CITY OF ALBUQUERQUE

February 21, 2017

RE: ST. Martins Hospitality Center
Grading and Drainage Plan
Engineer's Stamp Date 2-3-2017 (File: J18D182)

Based upon the information provided in your submittal received 2-8-2017, the above referenced Grading and Drainage Plan cannot be approved for paving permit until the following comments are addressed:

GRADING AND DRAINAGE PLAN

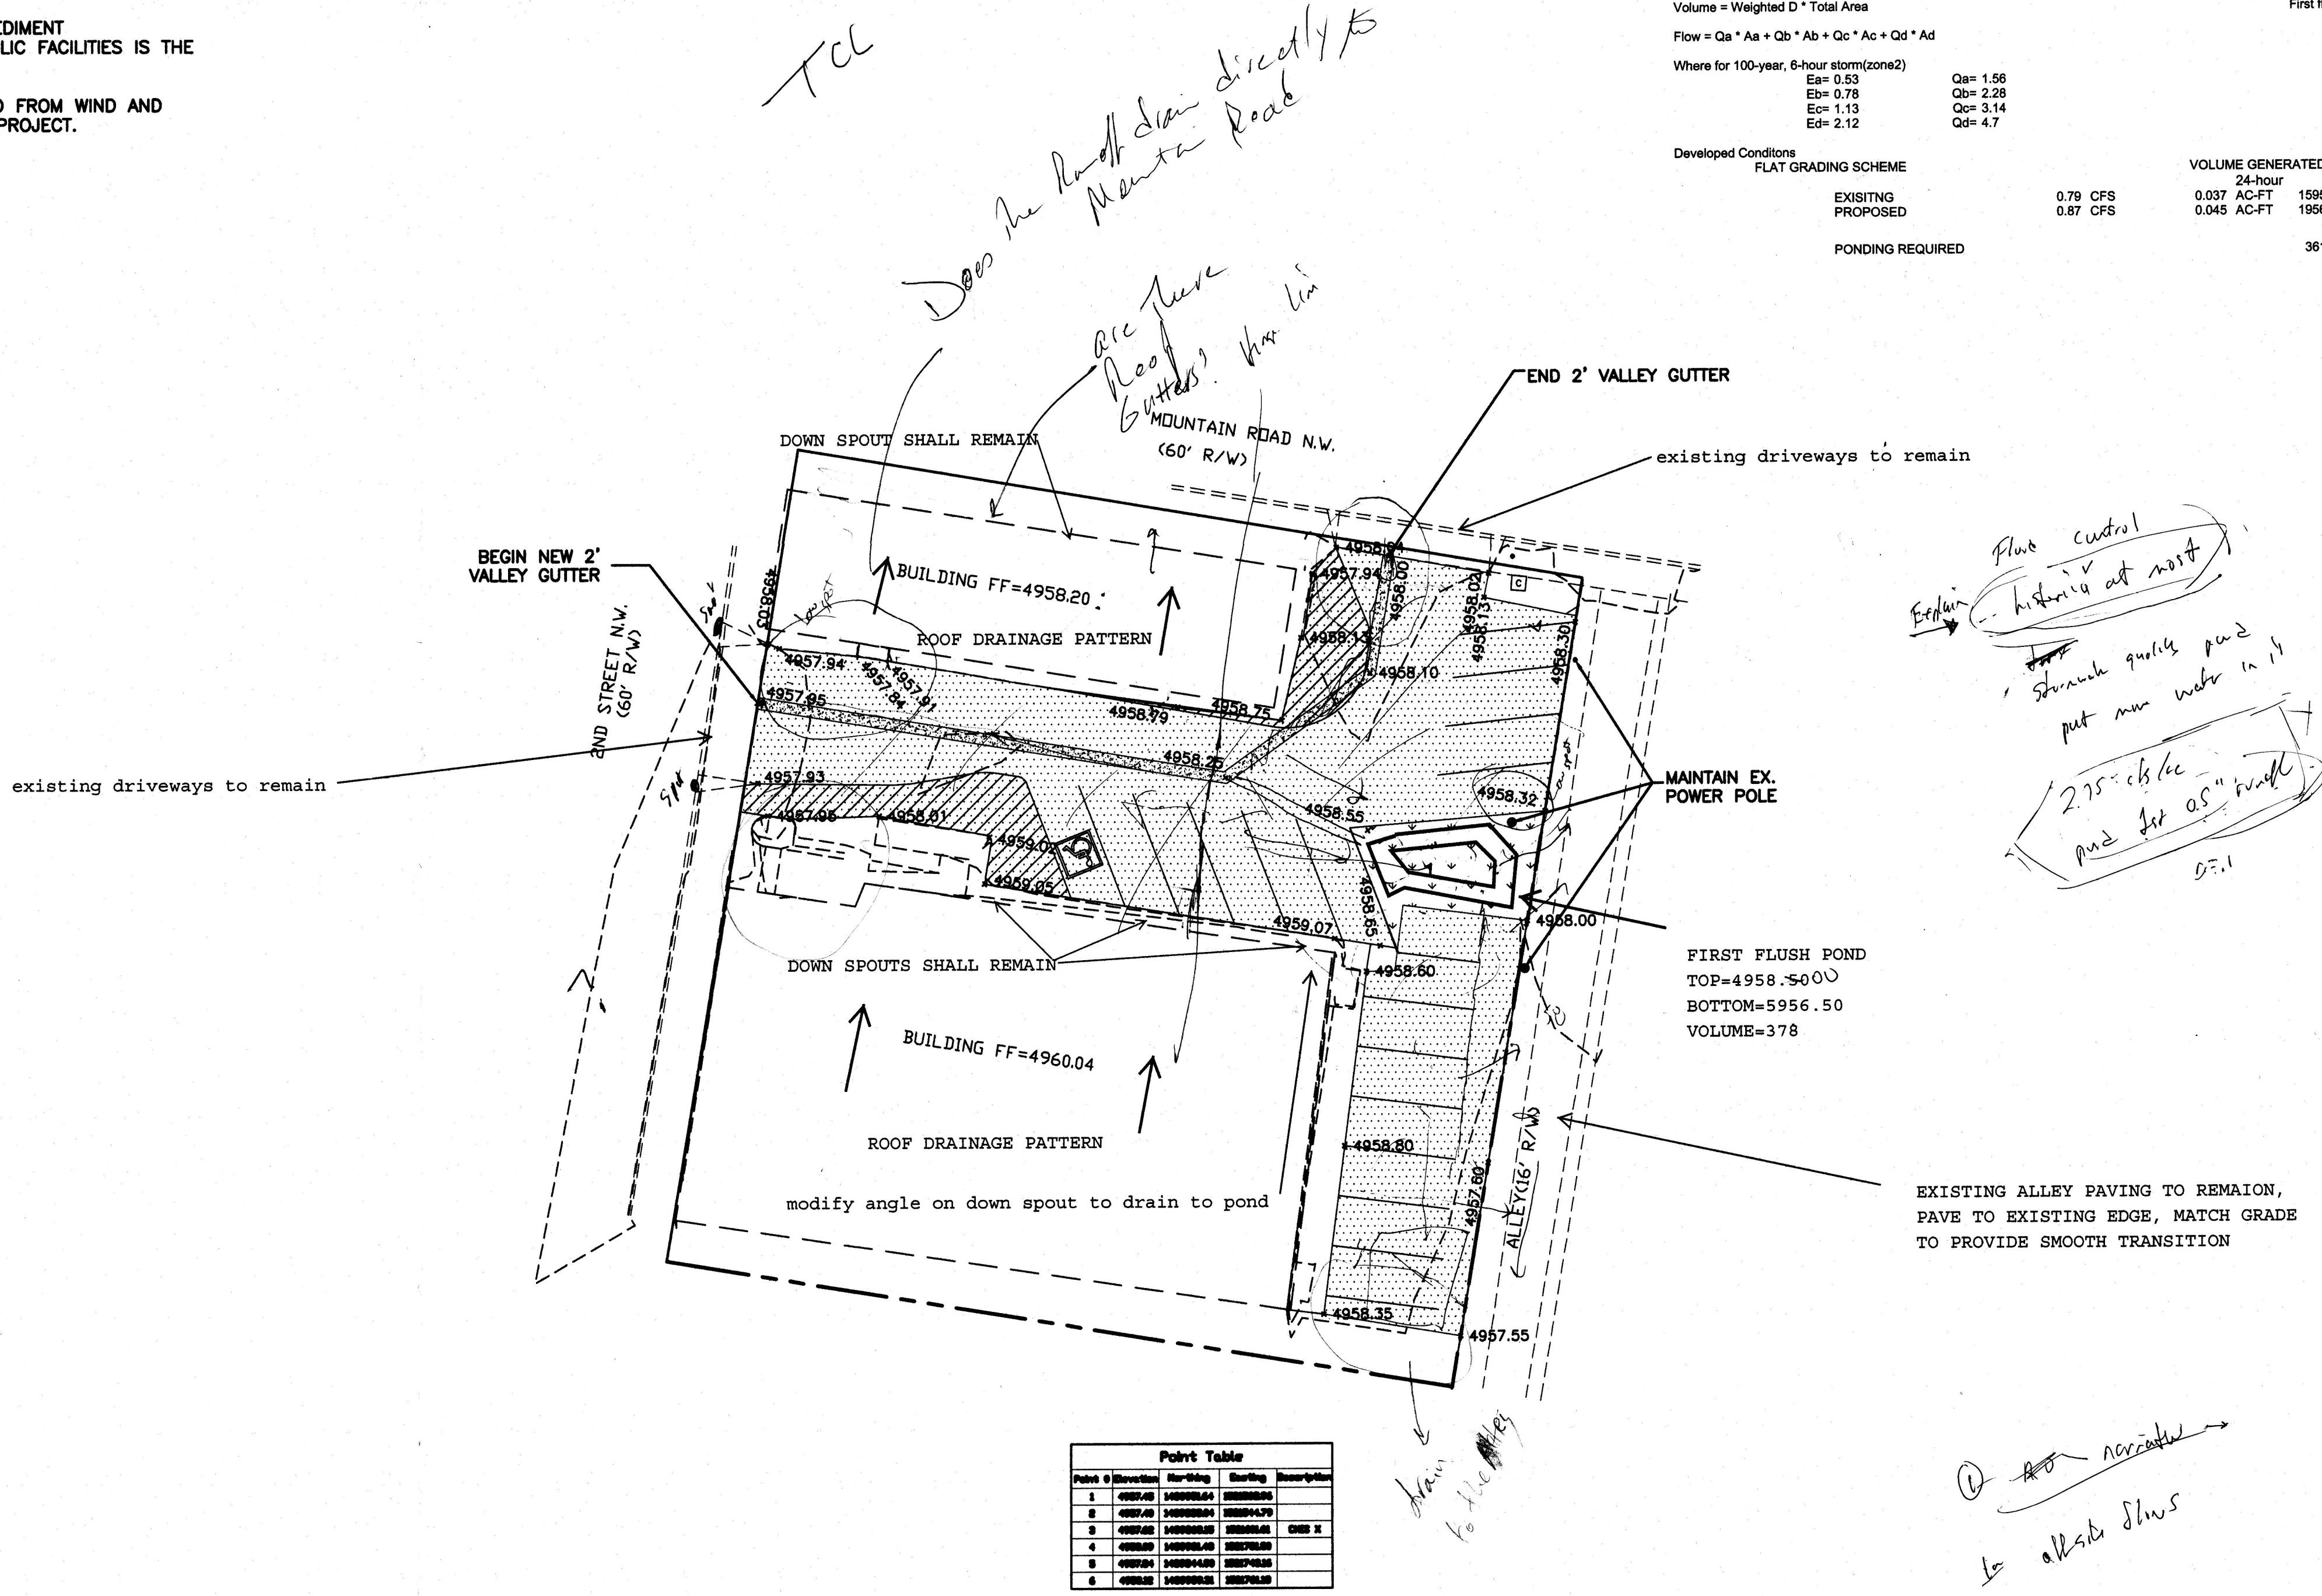
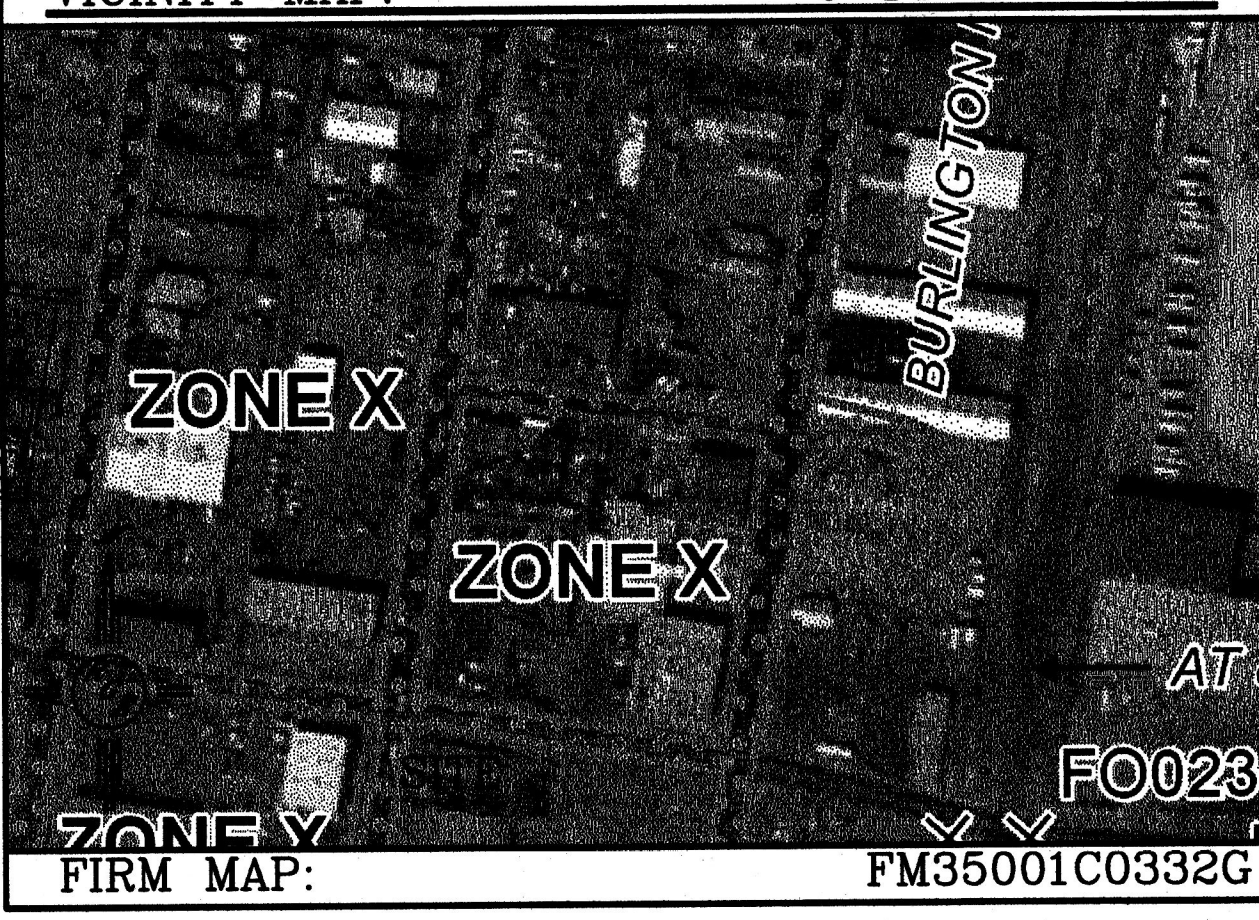
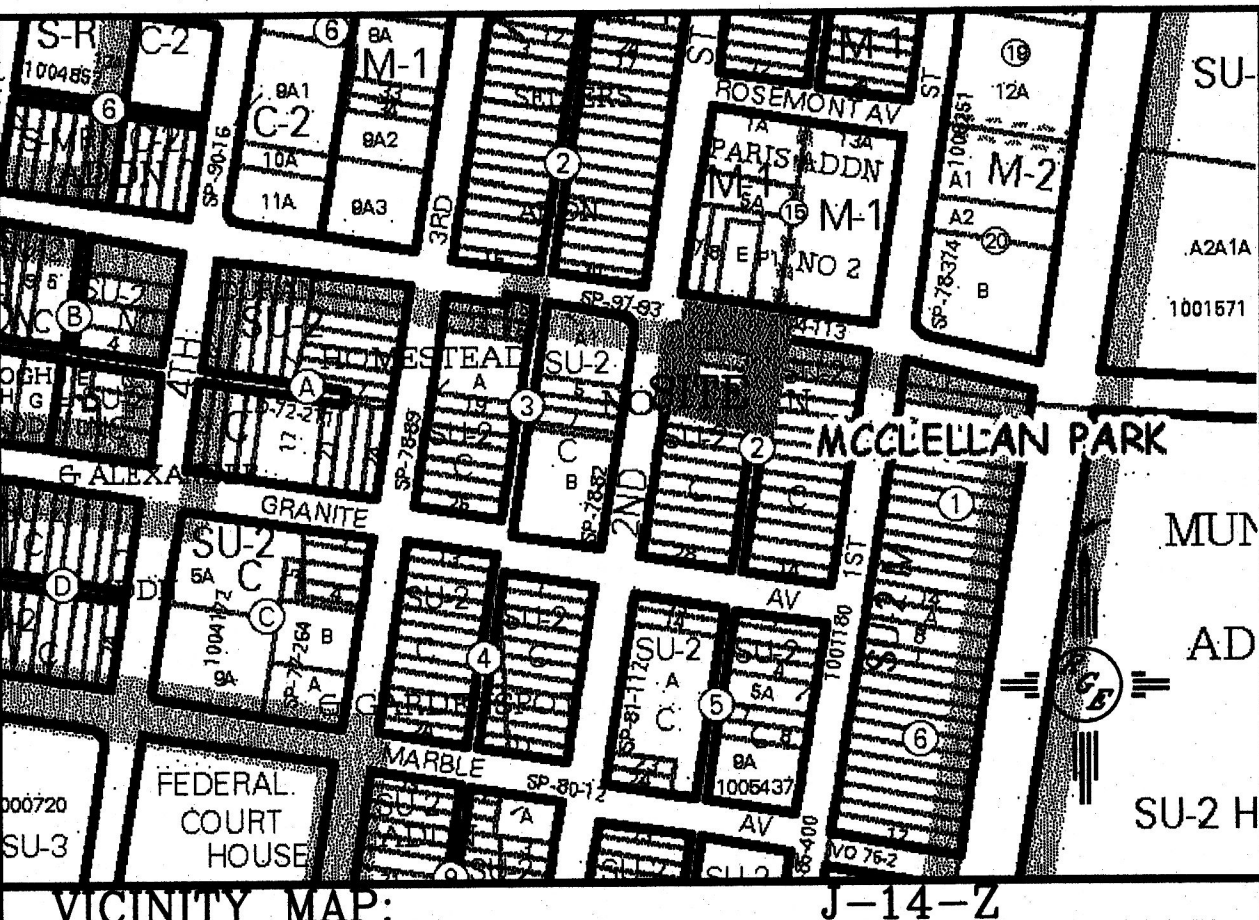
1. Provide onsite and offsite flow narrative.
2. Hinge line between the east and west side of the site will be beneficial to get half of the onsite runoff drain to the pond or make sure stormwater quality pond placed where flow can get to it.
3. Peak discharge for proposed condition should be the same or less than the existing conditions.
4. Does the northerly building roof drain directly to Mountain Road?
5. Is there a trash enclosure on site?
